March 21, 2023

**RE: Moran Development**

This letter includes our responses to comments received from City of Mercer Island regarding the Moran Development project on February 03, 2023. We have reviewed and revised the plan set and associated reports/documents to reflect the changes requested.

SHORING WALL PLAN

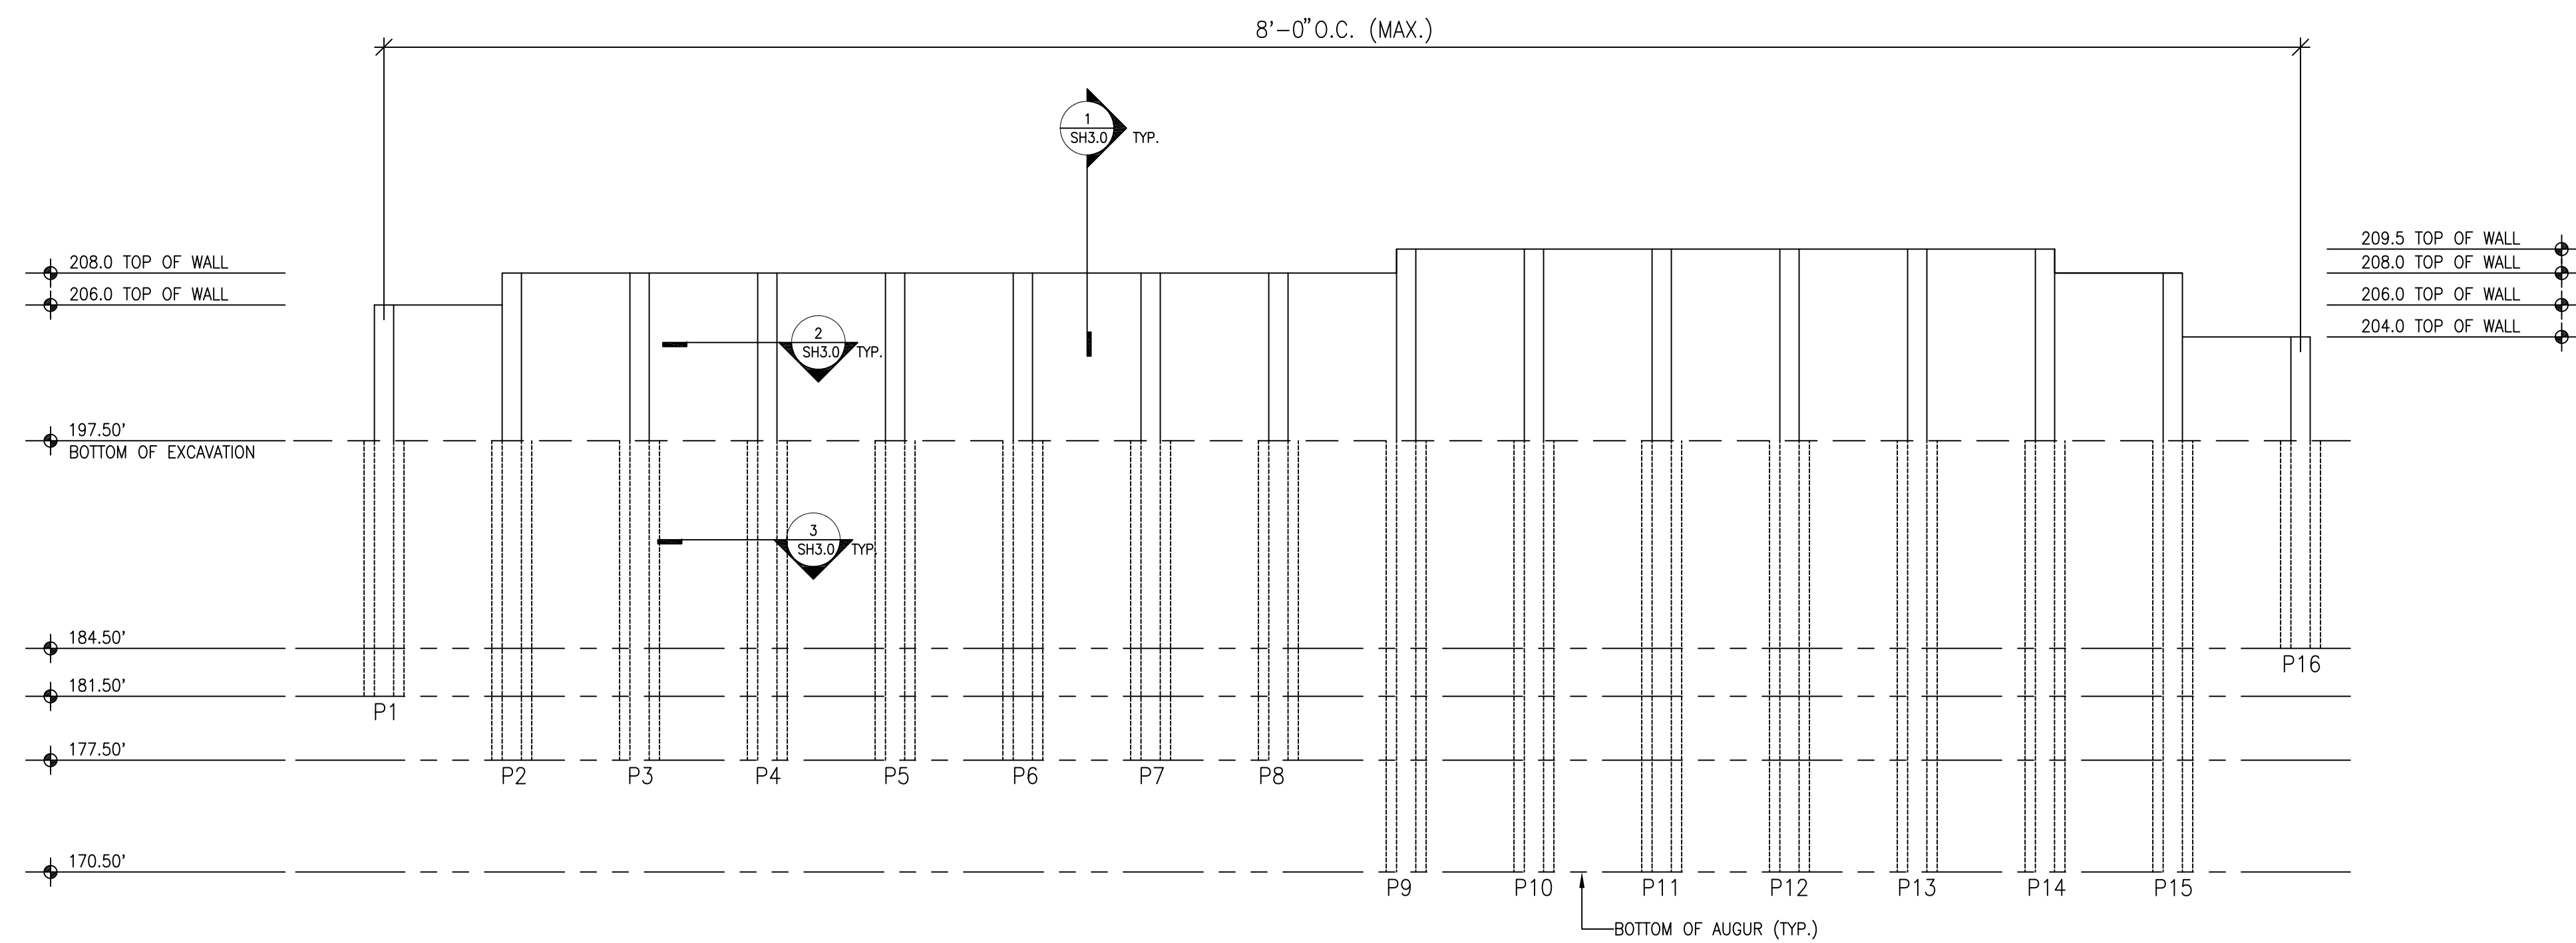
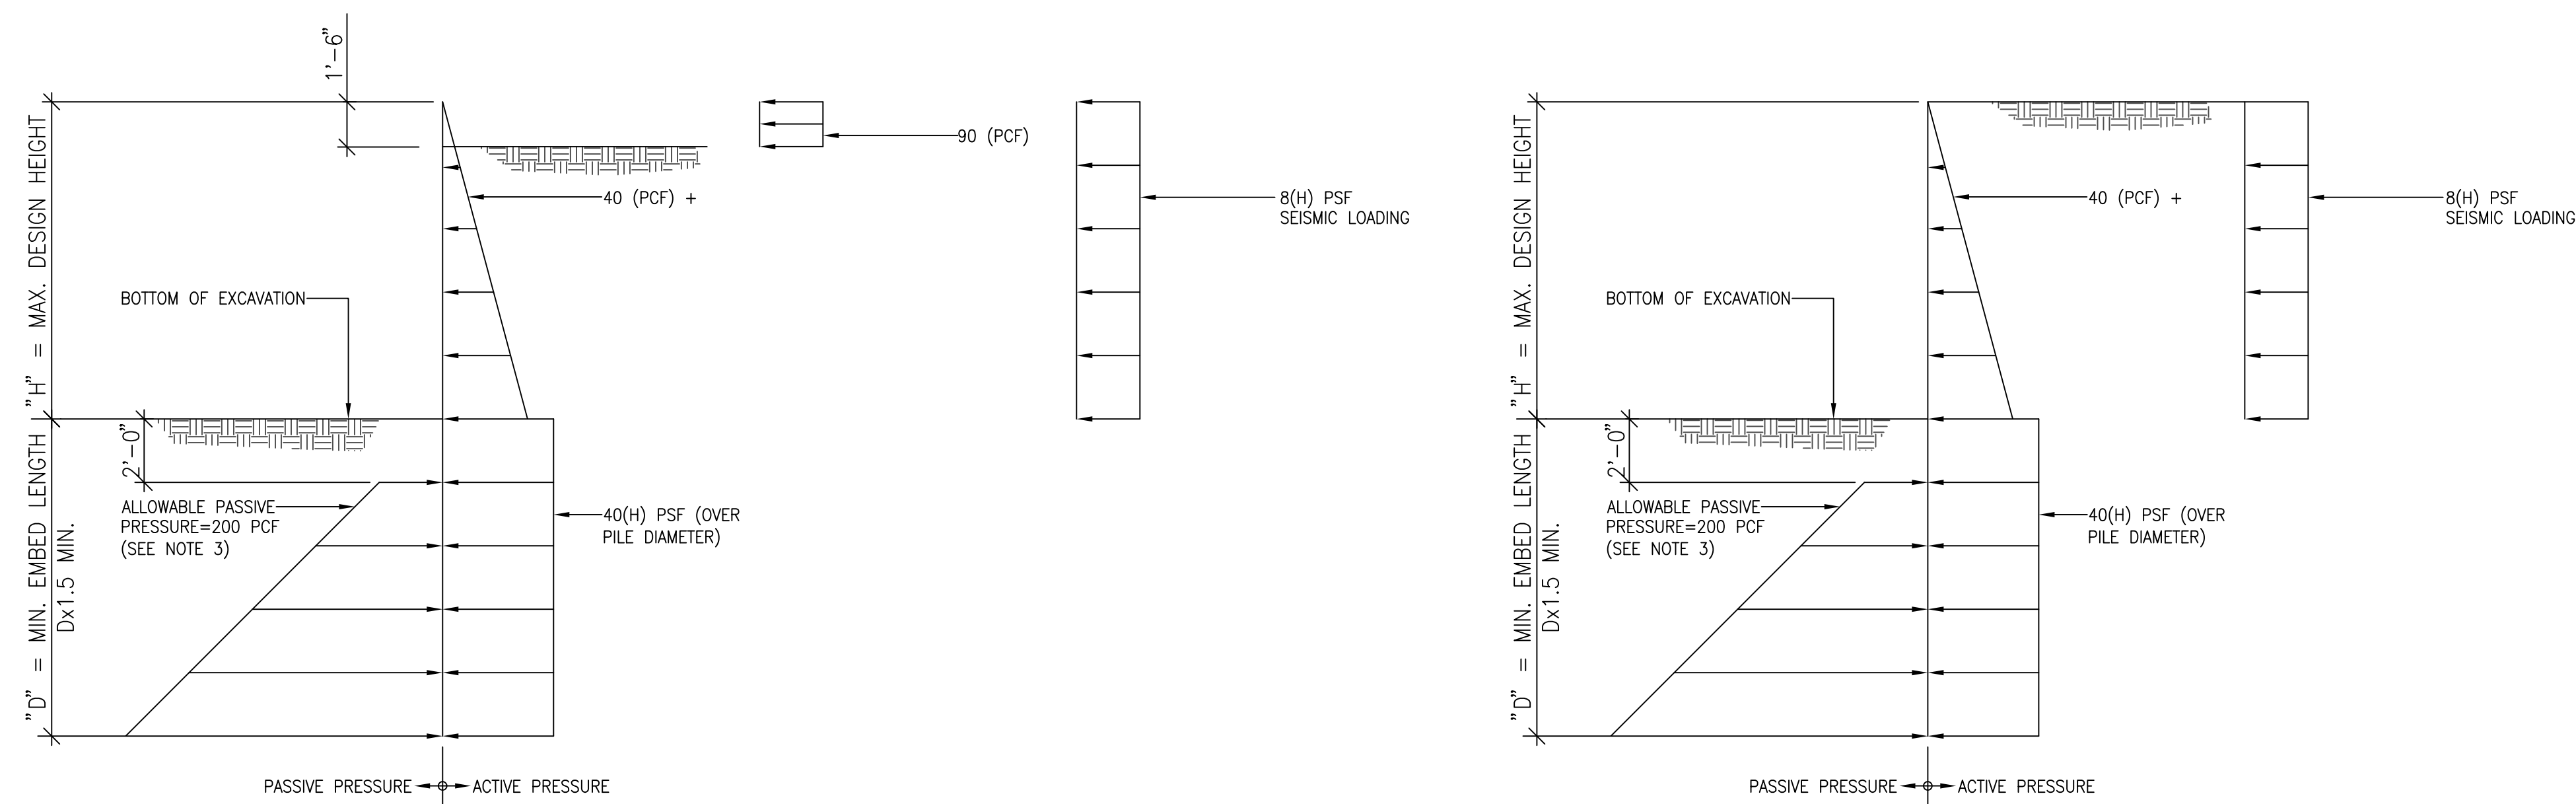
17. For structural and civil: SH-3 detail shows a 4" solid PVC pipe on the west side of the shore wall. This plan shows a 6" perf pipe on the east side. Please clarify if one or both are required. If both, show the design for the solid 4" pipe on this plan.

Response: Storm system updated to show 4" solid PVC pipe on the west side of the shore wall.

File: 1576001C-STRM.dwg Path: J:\1576 - Moran\001 - W Mercer Way\CAD\ Plotted by: JMU Team Date: 20-Apr-22 2:35:17pm

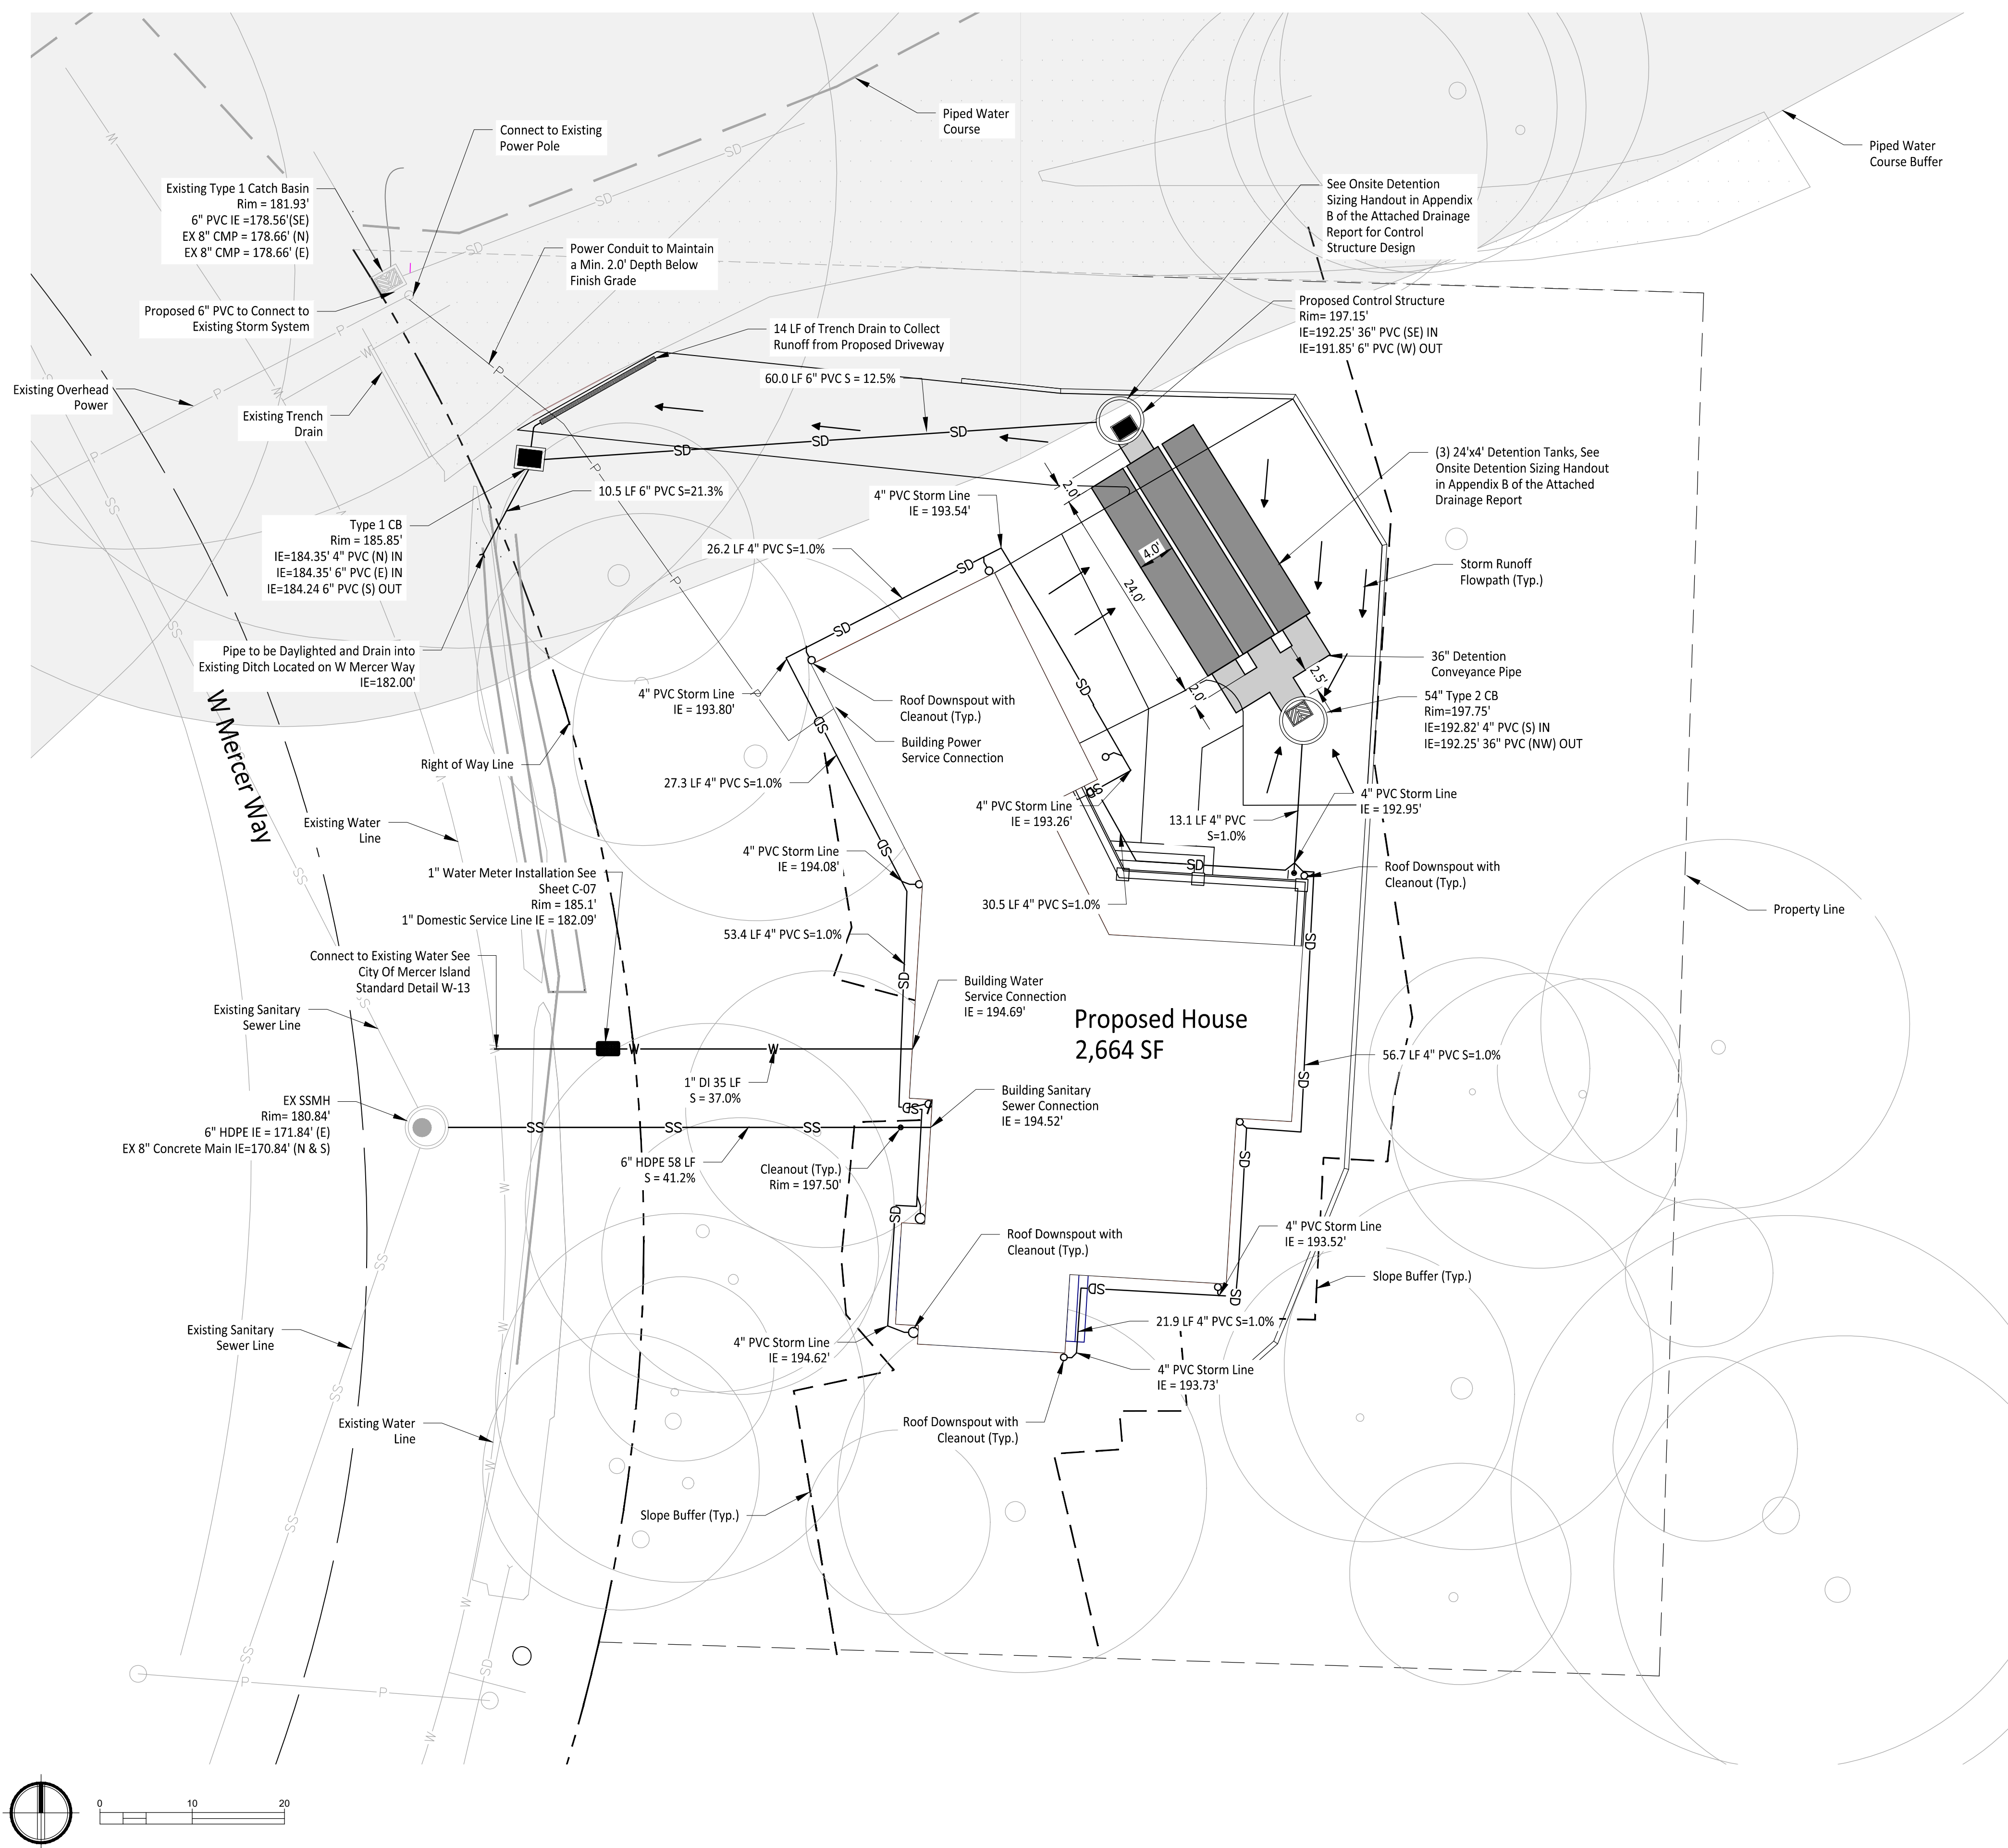
8. The pump system shall have dual, alternating pumps with emergency on-site, back-up power supply and an external alarm system for system failures. The proposed pump appears to only have a single pump. Provide supporting pump sizing and pump basin sizing calculations. Specify the required pump model and pump basin structure type/size on the plan and detail.

12. Double check outlet IE - current design will not gravity.

15. Show the layout and design info for the building footing drain connection from the building. Show IE at the connection to the building. Footing drain shall not be connected to detention system.

16. It looks like pipe anchoring is required for this side sewer and several other storm pipes. Provide pipe anchoring design and details for pipes exceeding 20% slope (storm, side sewer, typ.)

Response: Pumps system updated to have dual, alternating pumps with emergency on-site, back-up power supply and an external alarm system for system failures. Pump sizing and pump basin sizing calculations provided per Pump Technical Memo in Drainage Report. The required pump model and pump basin structure has been specified per detail.

Response: IE's have been updated to promote gravity flow to outlet IE.

Response: Layout and design info, IE, for the building footing drain connection from the building is shown. Footing drain ties into line running from detention tank to existing catch basin.

Response: Pipe anchoring standard detail has been added. Pipe anchoring added to pipes that exceed 20% slope.

Tree protection fence: 4-6" chain link fence, solidly anchored into the ground, or if authorized High-density polyethylene fencing with 3.5" x 1.5" openings; color orange. Steel posts installed at 8' o.c.

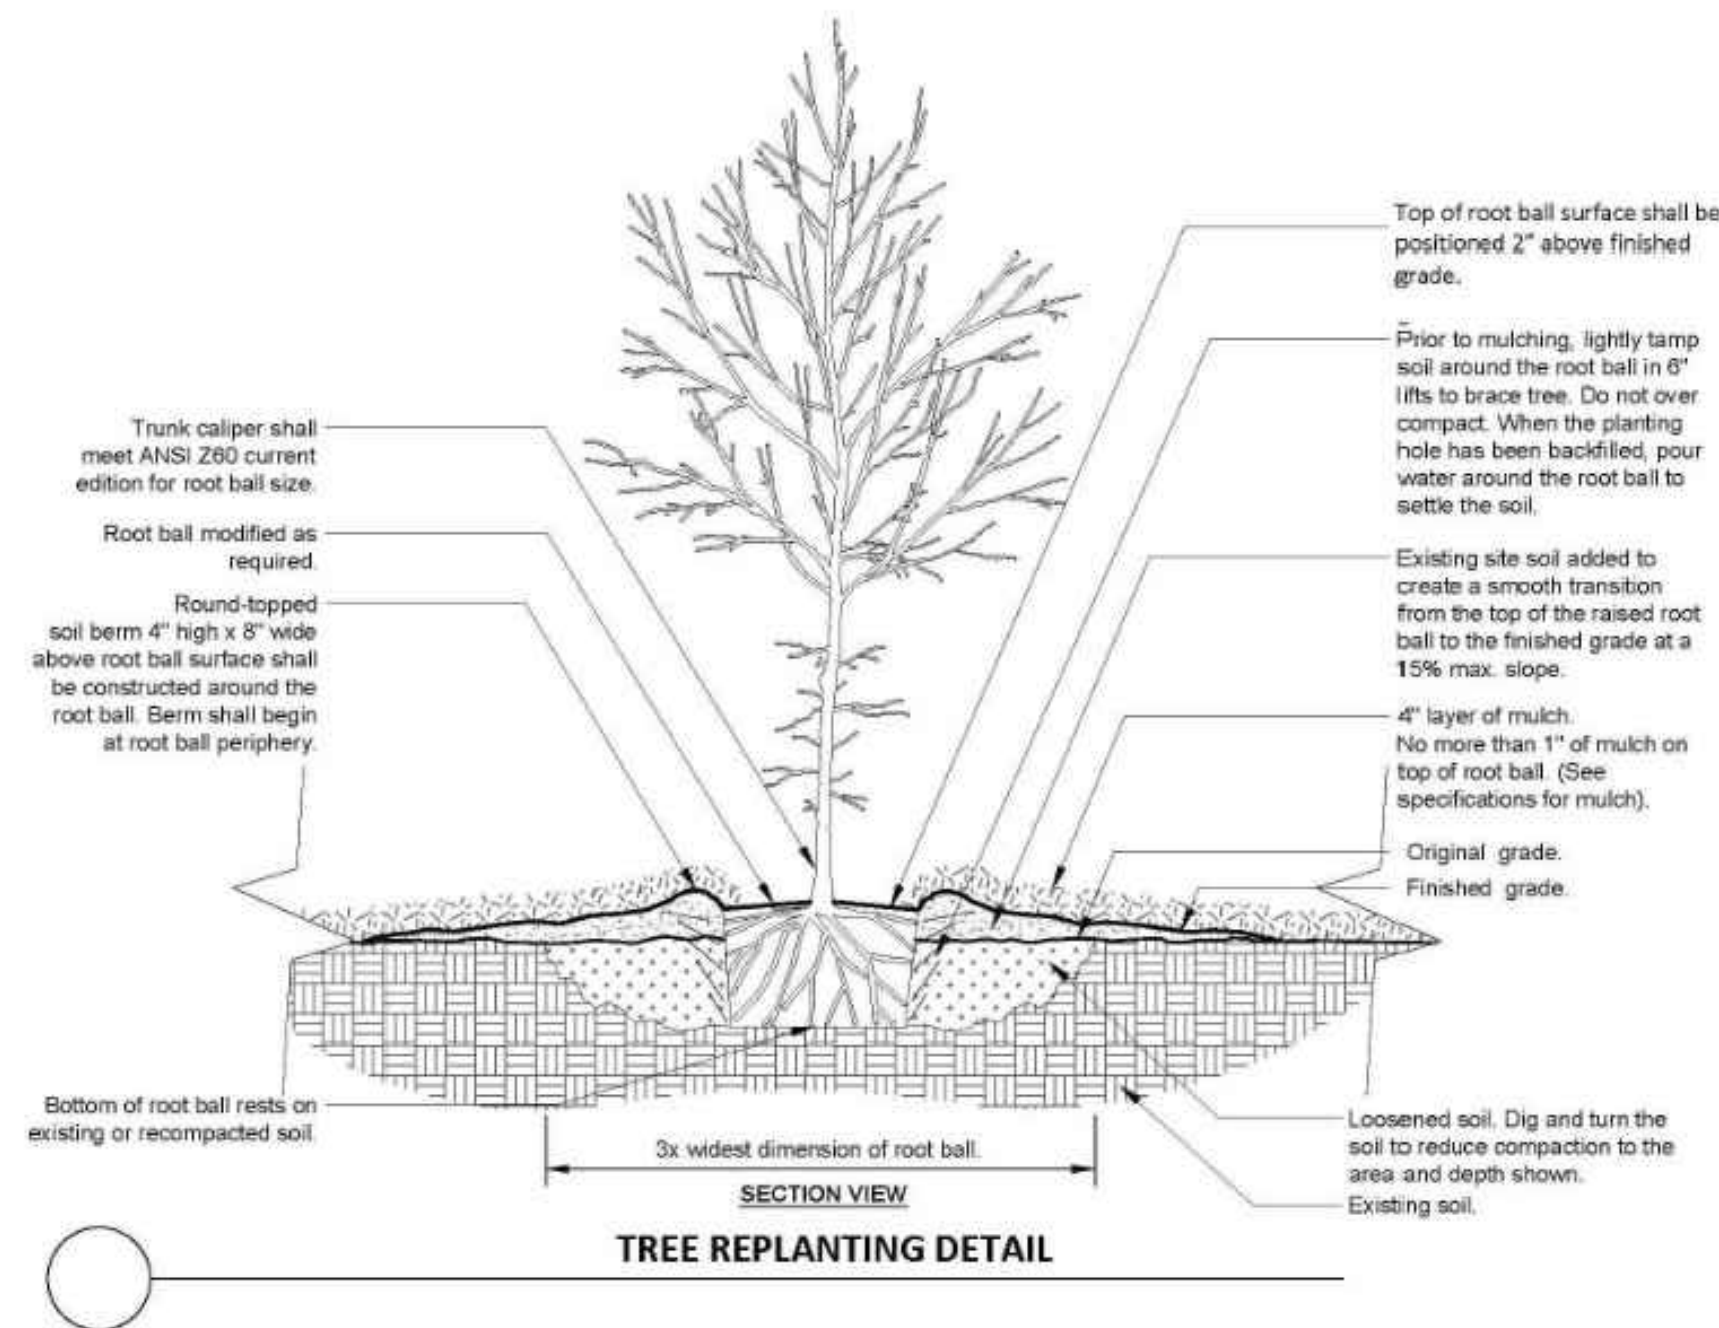
1. Update Tree Protection Plan with all civil information. Including all utilities, all grading and retaining wall should be shown and kept outside of exceptional trees driplines. Show over excavation for retaining wall. HYPERLINK  
"[https://www.mercerisland.gov/sites/default/files/fileattachments/community\\_planning\\_amp\\_development/page/21988/treessubmittalchecklist.pdf](https://www.mercerisland.gov/sites/default/files/fileattachments/community_planning_amp_development/page/21988/treessubmittalchecklist.pdf)"treessubmittalchecklist.pdf (mercerisland.gov)

2. Either move all utilities outside tree protection zones. Or call out tunnel/bore within trees driplines. And move water meter or install with air excavation and arborist supervision. Move tree protection fence at the edge of the utility easement to protect tree 20. Remove grading that is proposed within exceptional tree 20's dripline, grading/excavation can be in the easement. See comment 1, exceptional trees must be protected or protected according to MICC19.10.080. And comment 3 requiring all work and trees to be on one plan.

**Response: Added Tree Protection plan to civil sheets. Utilities, grading, and retaining wall shown and kept outside of exceptional tree driplines. Over excavation for retaining wall shown.**

**Response: Utilities moved outside tree protection zones. Sewer line called out to be excavated using pneumatic or hydro excavation or hand excavation.**
